Our ref: F2007/00656

Re: Modification 4 (DA246/96) Second Thermal Oxidiser

Thank you for the opportunity to comment on the Section 4.55(1A) modification (Modification 4) application to modify DA246/96 for the existing Terminals bulk liquid storage facility to construct a new thermal oxidiser with associated servicing and infrastructure adjacent to the existing combustor; demolition and removal of existing waste tank 1 (WT1) and repurposing of tank T-261 as a new waste tank at the site.

PLAN A
SCALE 1:100 LAY001

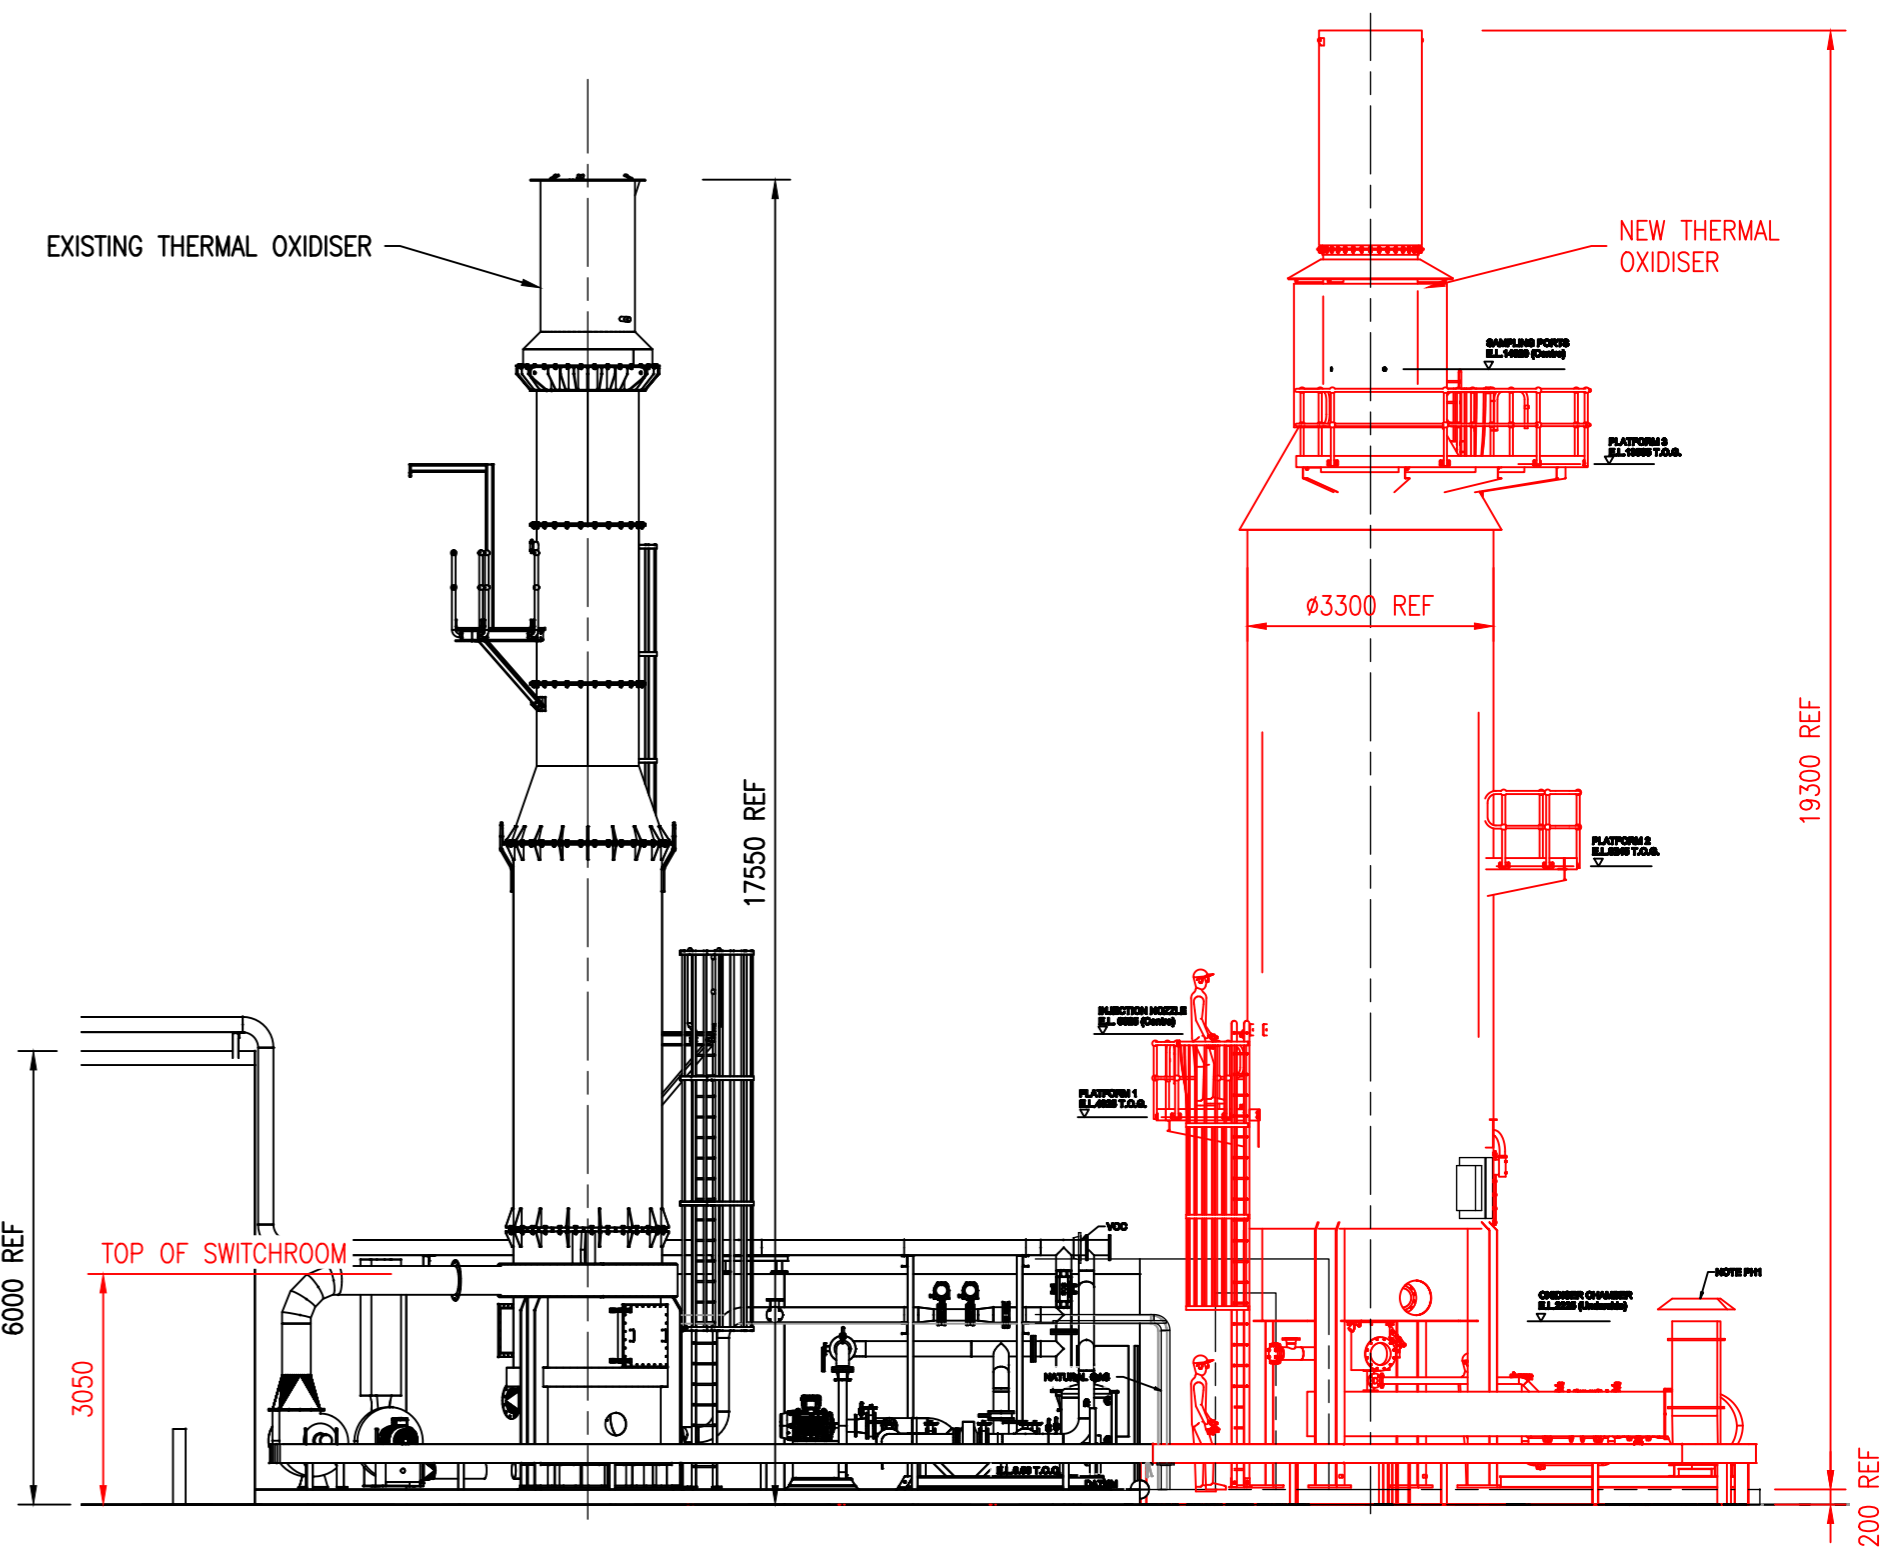
- The GASCO letter dated 20 May 2021 advises that complete combustion of the liquid fuel waste must be achieved through a residence time of 2 seconds and temperature of 980°C in the combustion chamber. However, it is not confirmed that the internal volume of the mixing chamber will be sized to achieve this. It is imperative that the residence time of 2 seconds and temperature of 980°C is achieved in this proposal. Any potential shortcomings and/or obstacles to achieving and maintaining this internal volume to achieve the designated residence time and temperature can only be adequately addressed via a development application.
